**From:** Simon Davis <Simon.Davis@arun.gov.uk>  
**Sent:** 07 January 2022 18:06  
**To:** Tilly Whishaw [REDACTED]  
**Cc:** Craige Burden [REDACTED]; Roger Spencer <Roger.Spencer@arun.gov.uk>  
**Subject:** RE: Planning Consultation on: Y/163/21/DOC Land at Street Buildings

Please see the updated Drainage Statement and Drainage Maintenance Manual at the following link: <https://we.tl/t-ARqgxhJwJB>

We have responded to Rogers comments as follows:

Proposed Drainage Design Layout Sheets

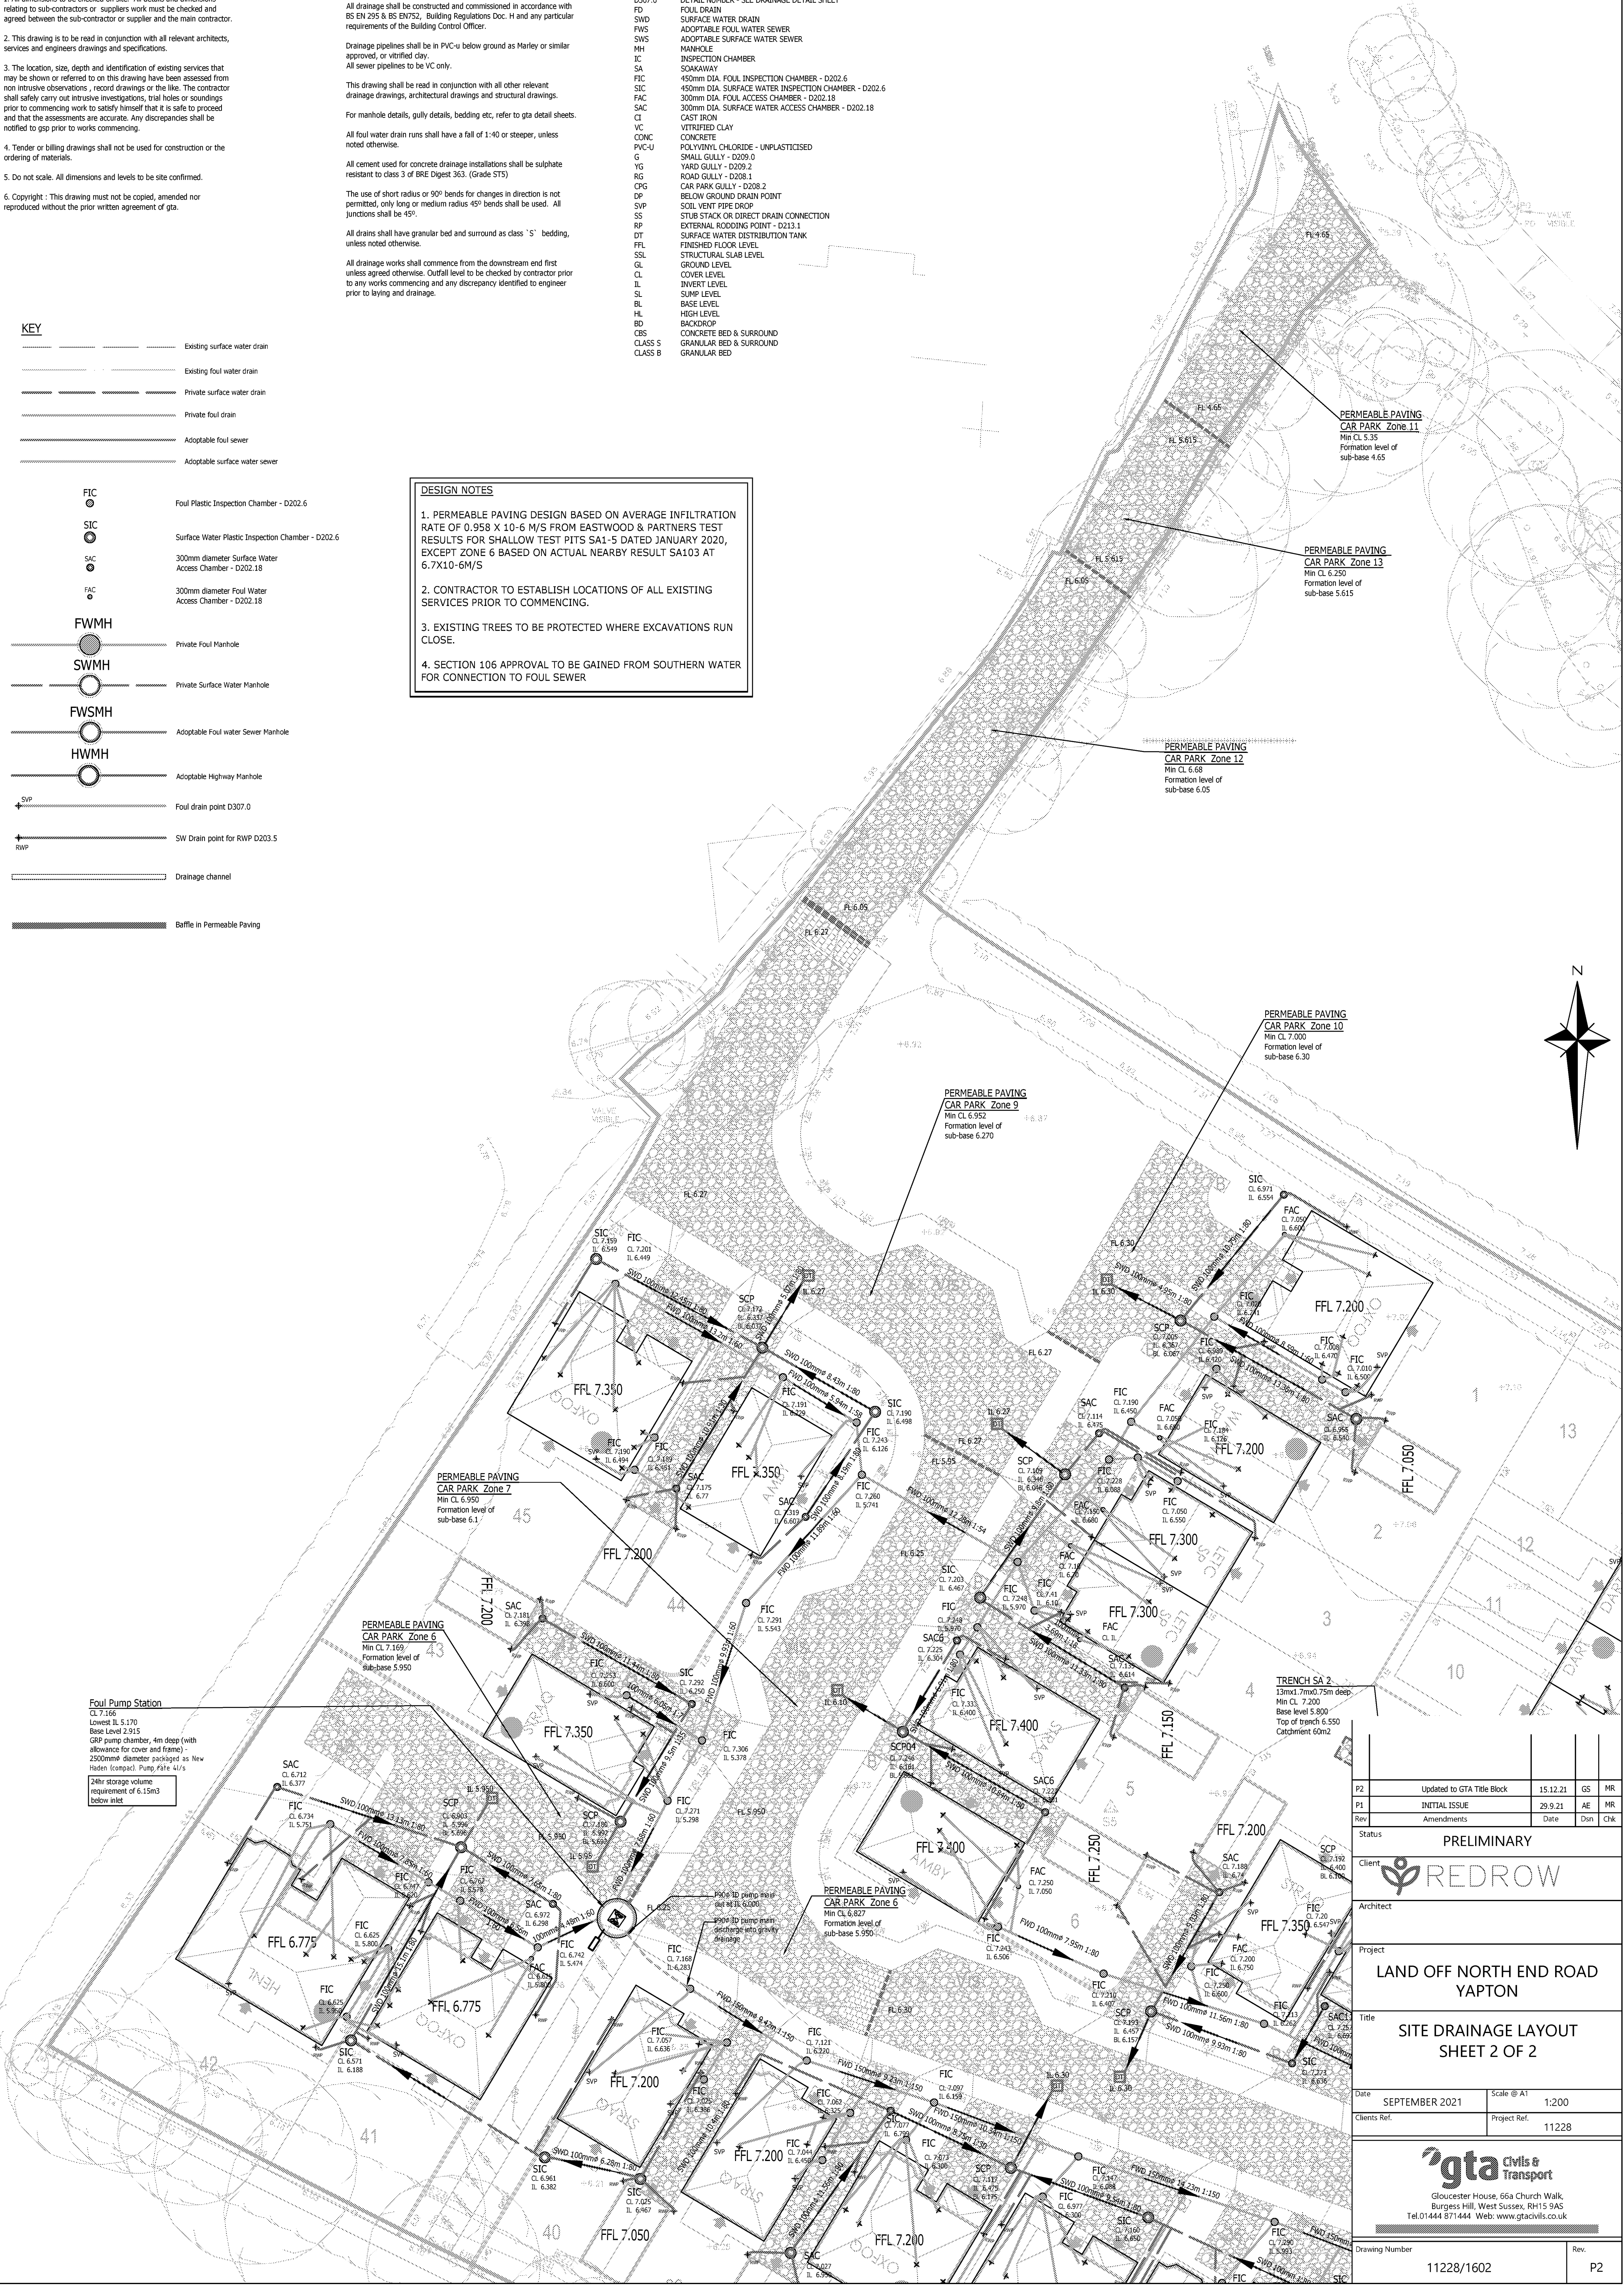
1. The drainage layout is included in the Foul & SuDS Drainage Statement & Maintenance Plan but I note that a previous comment relating to an infiltration blanket for Zone 9 is not addressed. I would also suggest that the document contains a lot of information that is not relevant to ongoing maintenance; it would therefore benefit from the content relating to maintenance and management being separated out into a standalone document – with relevant information (plans & drawings etc.) pulled into it. The maintenance manual has now been separated from the Drainage Statement. The infiltration blanket has been removed from the calculations. The revised MD calculations are included within the Drainage Statement.
